Please ask for: Ms Iqraa Malik
Email: iqraa.malik@terraquest.co.uk
Telephone: 01212341390
Our Ref: Y/35/21/HH
Your Ref:
Date: 19th March 2021

Application for Planning Permission for Works or Extension to a Dwelling

Development: PROPOSED REAR ADDITION
Location: 35 Park Drive Yapton BN18 0JF

existing side (east) elevation
SCALE 1:100

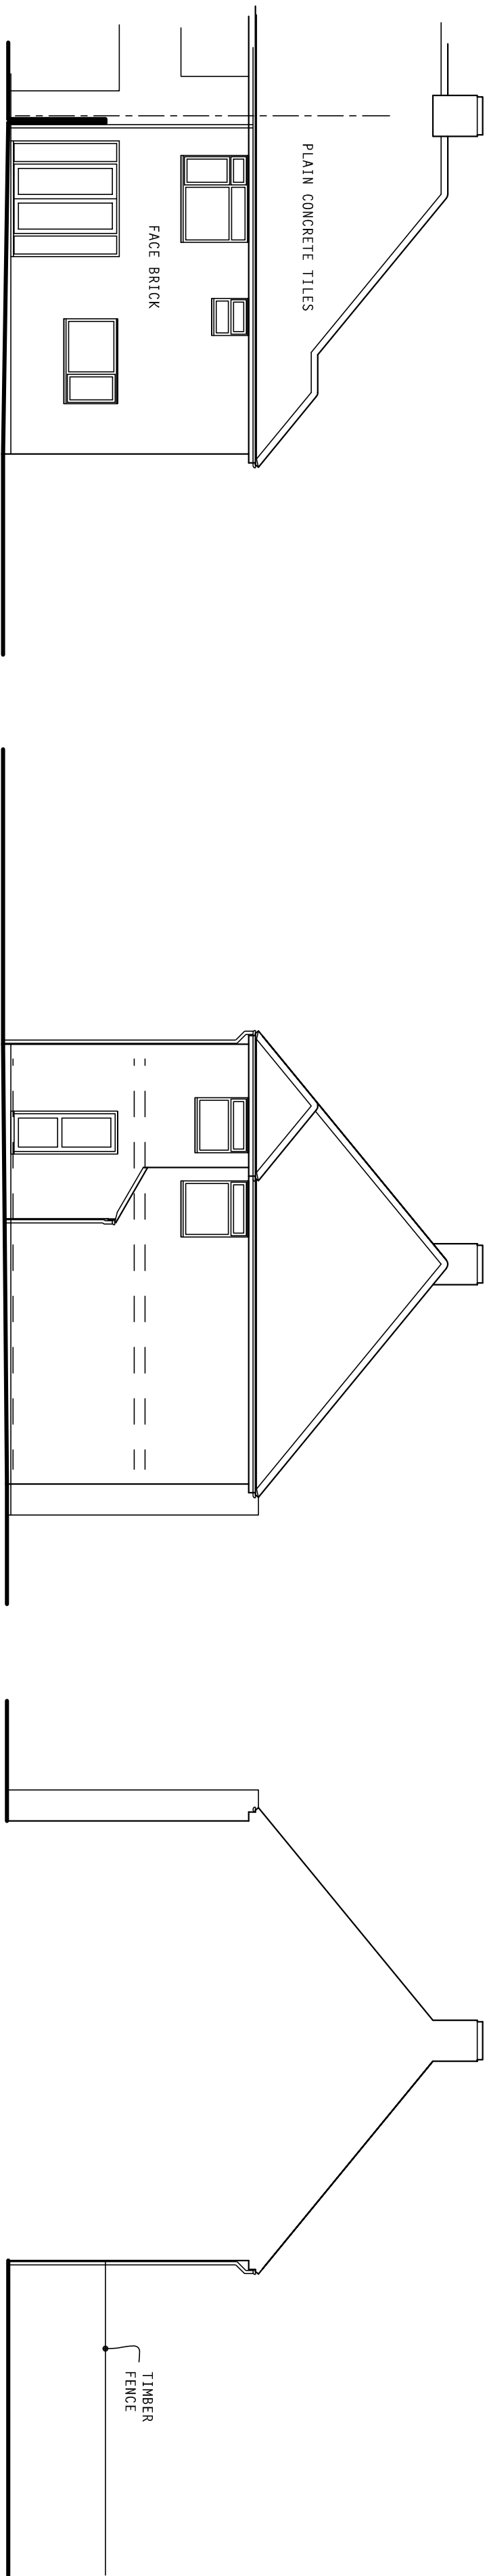
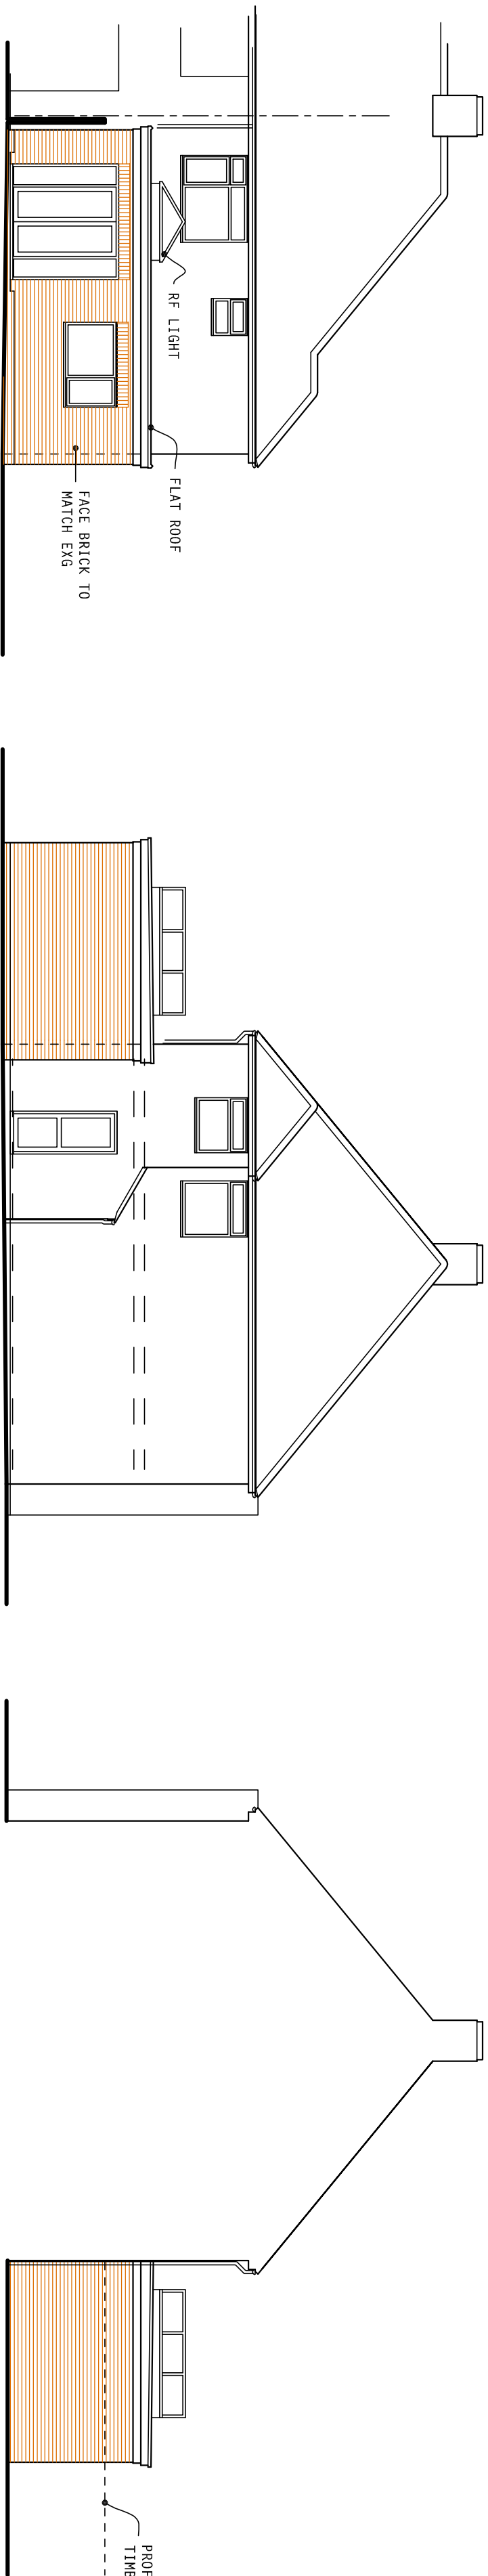
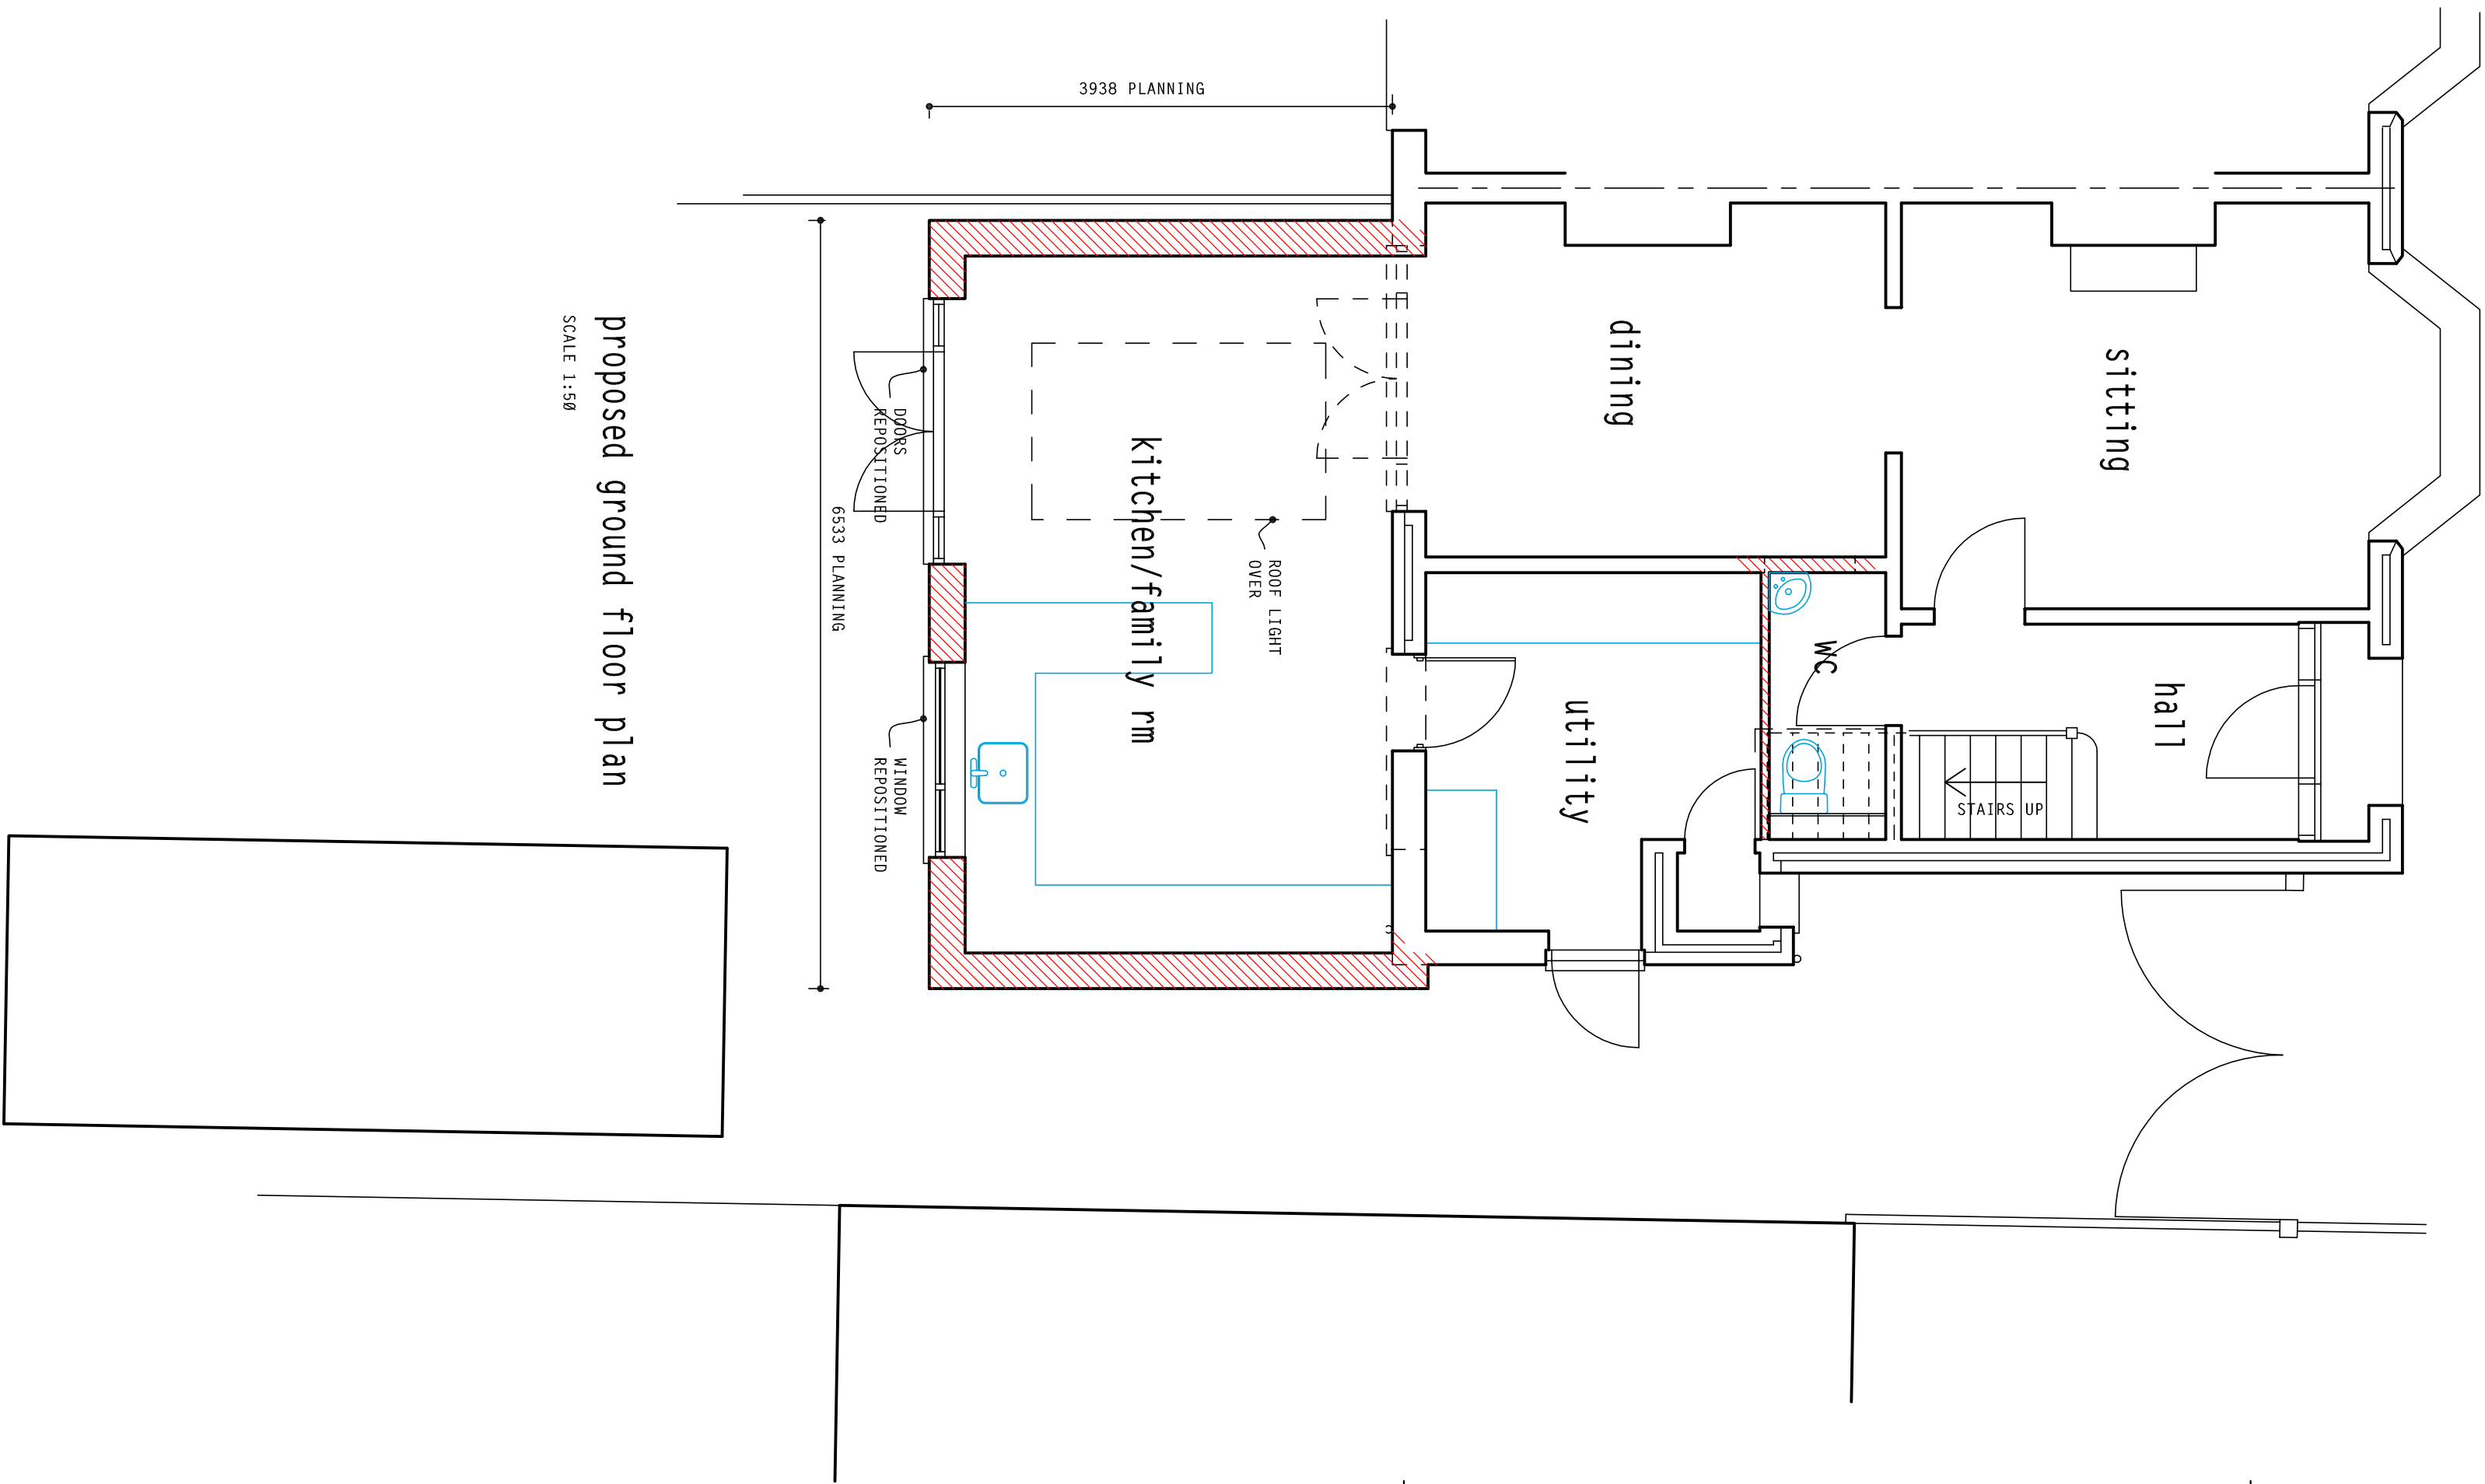
Please submit a copy of clearly labelled other side elevation at a scale of 1:50 or 1:100. Further details can be found in the Validation Requirements List.
